Monday 8<sup>th</sup> March 2021

**RE: Dubbo Quarry Continuation Project (SSD 10417) Notice of Exhibition – Submission Letter**

FIGURE 1
PROJECT LAYOUT
MAC190962-03
Holcim Dubbo Quarry
Continuation Project
Acoustic Review

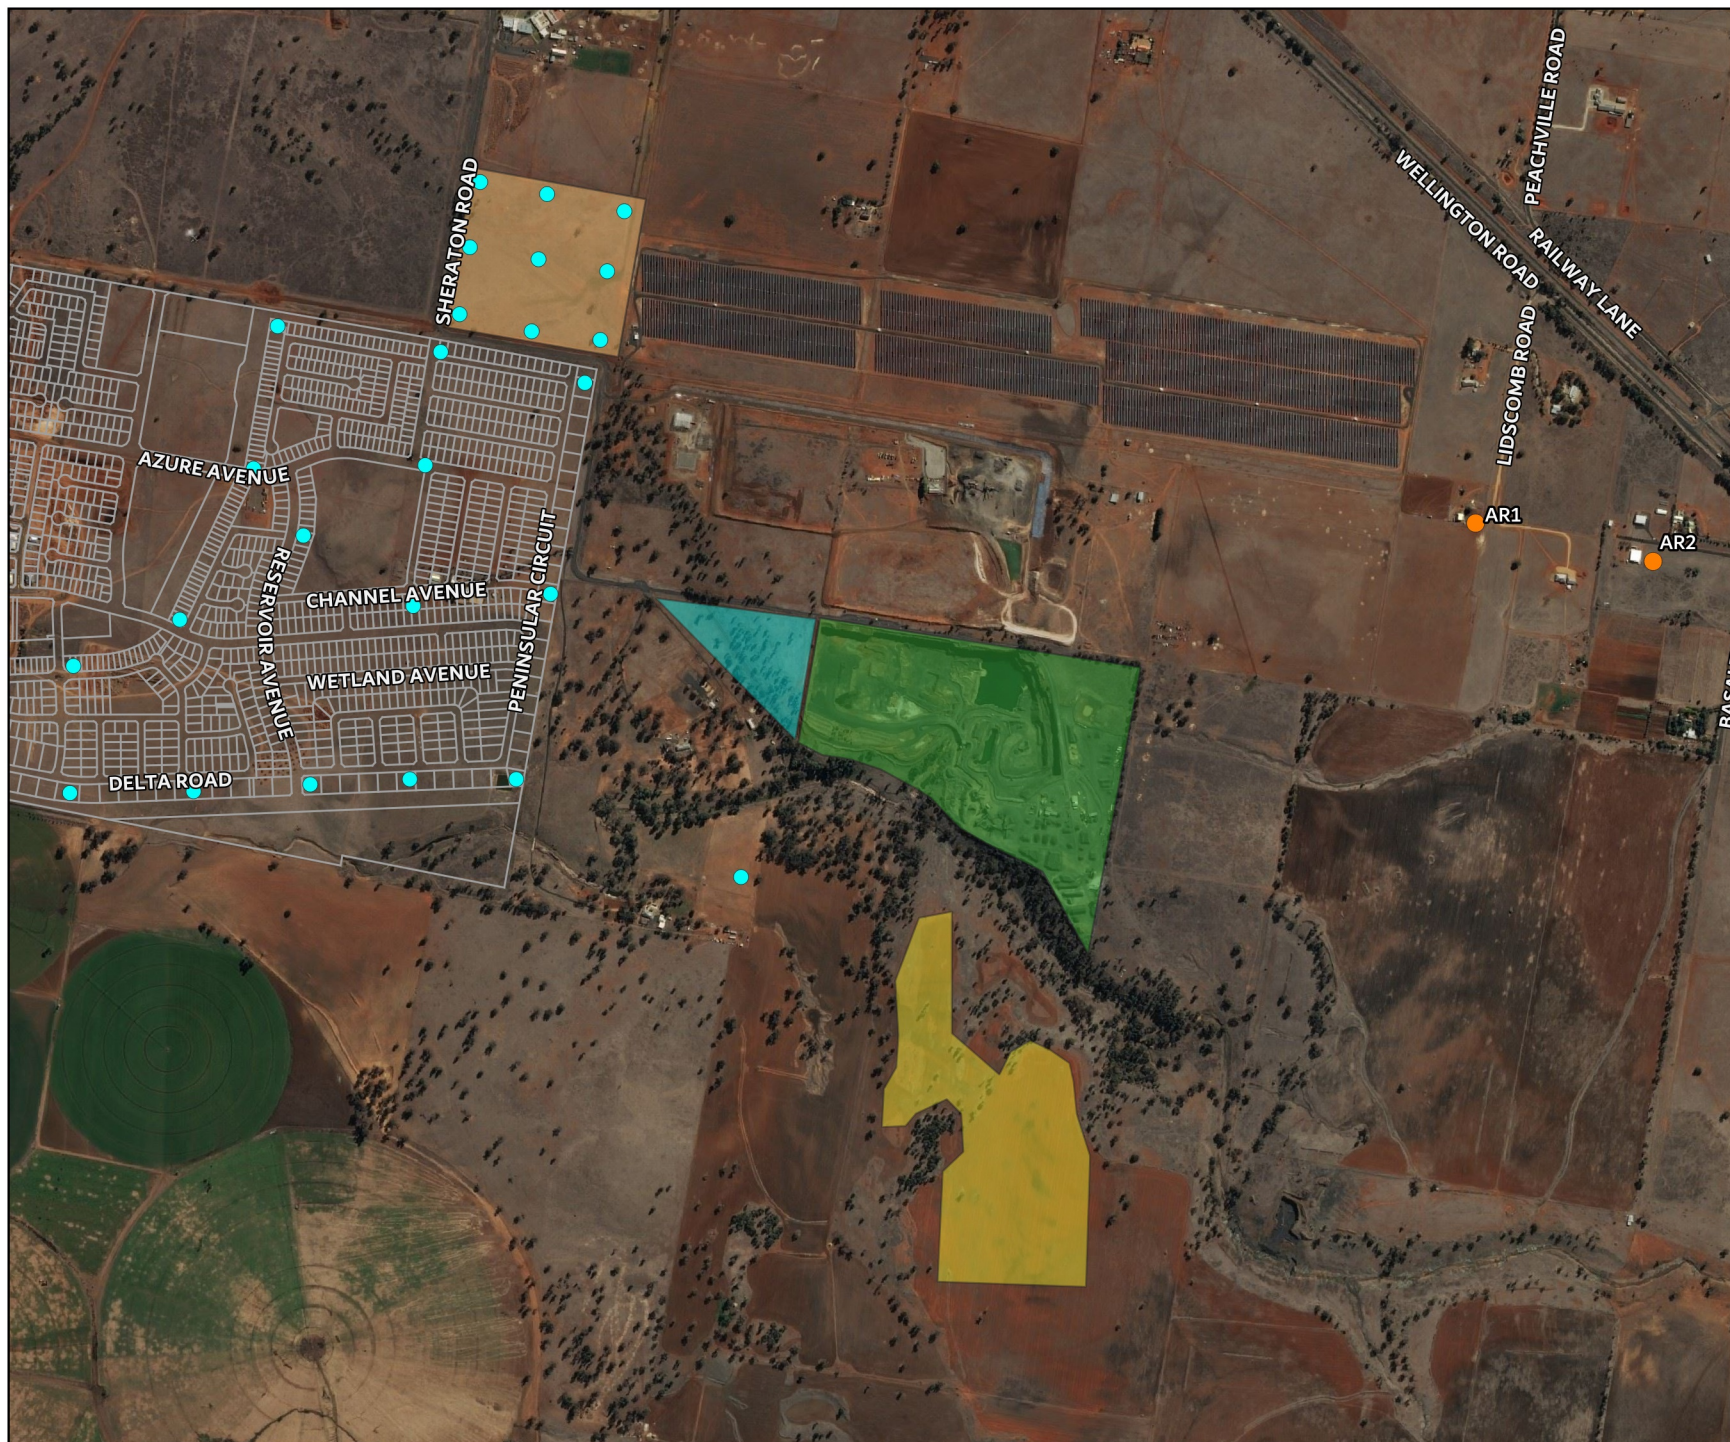
- The NVIA has not assessed quarry noise emissions and road traffic noise at all residential receivers within the potentially affected area of the quarry extension including the potential future residential receivers in the Sheraton Road Estate and the Southlakes Estate.

- Production of noise contour diagrams for five yearly stages for quarry operations, stripping and drilling would allow for a more transparent understanding of the noise impacts at the potential future residential receiver locations in the Sheraton Road Estate and Southlakes Estate subdivisions.

- Predicted noise levels from normal operations exceed the daytime and night time PNTLs and the recommended ANL of 45dBA for rural receivers for the life of the quarry at R2, R3 and R23. It is anticipated that noise levels would also exceed the daytime and night time PNTLs for the life of the quarry at the proposed dwelling at 25R Sheraton Road and future residential receivers in the Southlakes Estate, situated between R2 and R23.
